From: [Wedin, Lathan](#)
To: [Kelee Hodges](#); [Josh Fredrickson](#)
Cc: [steve.lathrop1](#); [steve.lathrop1](#); [Kelly Bacon \(CD\)](#)
Subject: RE: LP-22-00004 Suncadia Ph 1 Div 14 - Preliminary Plat PW Survey Review
Date: Friday, November 18, 2022 12:37:58 PM
Attachments: [image001.png](#)
[LP-22-00004 Suncadia Ph 1 Div 14 KCPW Plan Review Team Comments 11172022 Revised.pdf](#)

Josh, as Kelee's email below asks to get in touch with you, I have attempted via phone this AM to no avail. If you could please give me a call at your earliest convenience regarding the revised survey comments, or verify by email that the below positions are correct so we don't have any unknown hurdles for our preliminary plat for P1D14:

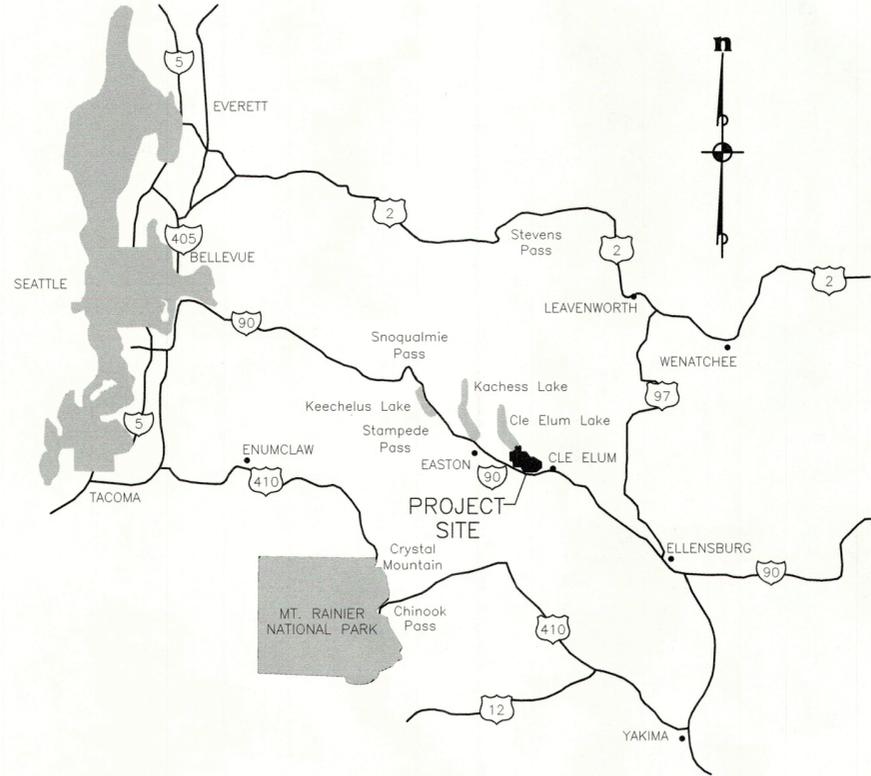
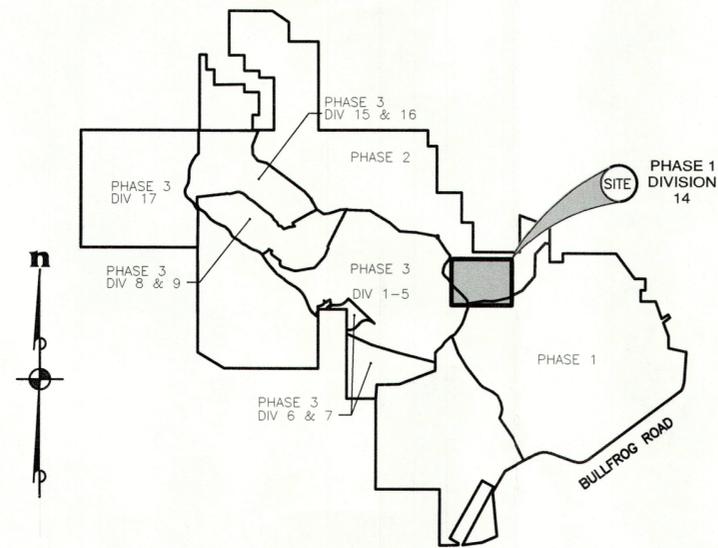
I also clarified Public Works Survey comment #4 (copied below) with our civil engineer and essentially that comment does not apply to preliminary plat / Suncadia. The easements have been contemplated, but at preliminary plat everything has not been fully designed therefore no easements exist at this point.

“4. Sewer, stormwater, and road cut/fill slope easements should be contemplated. All easements shown upon referenced conceptual and preliminary documents shall be included on the face of the Plat.”

Comment #4 also appears to be a conditional preliminary plat comment and does not pertain to the easements yet to be determined as construction documents/etc. are finalized prior to final plat. It seems this comment/code is stating to show any 'existing easements' that would be on this property, of which there are not any in this instance.
